AB/47/22/A

2 Maltravers Street Arundel BN18 9AP

1 No externally illuminated hanging sign & 1 No externally illuminated informational sign

PROPOSED SIGNS AND LIGHTS
SCALE 1:5

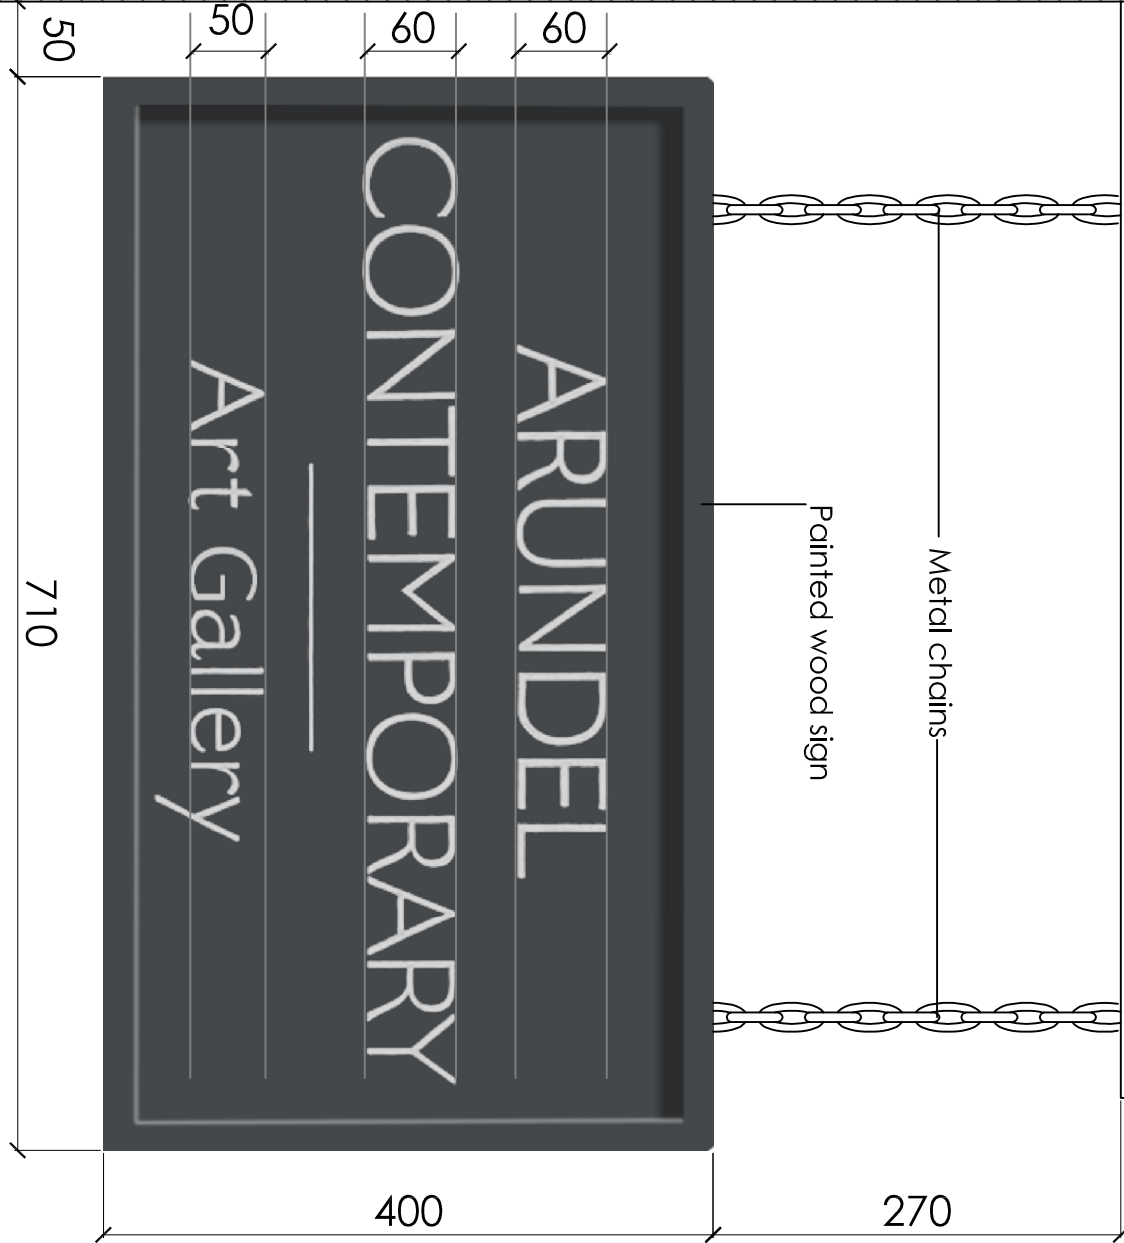
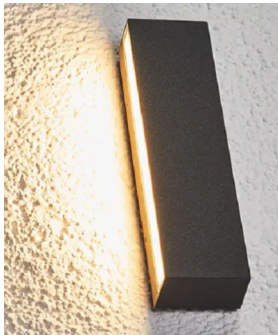
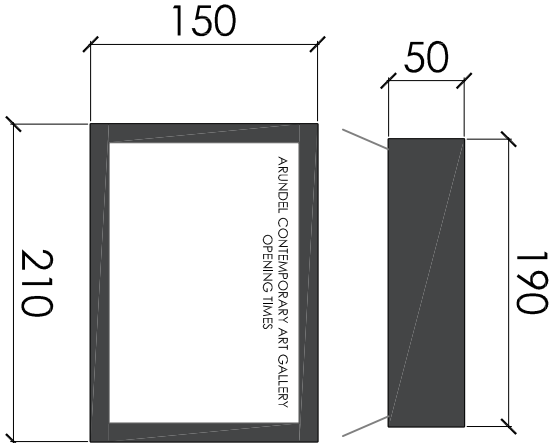
The town centre contains number of uses including residential, restaurant and retail. The information panel and light, along with the new hanging sign are a simple design and do not cause harm to the appearance or significance of the building and are therefore considered to be acceptable. When installing the signage and lighting the applicant should stick to the principles of reversibility so that no part of the installation leaves a permanent scar. This means using methods like only fixing into mortar joints and not the brick.
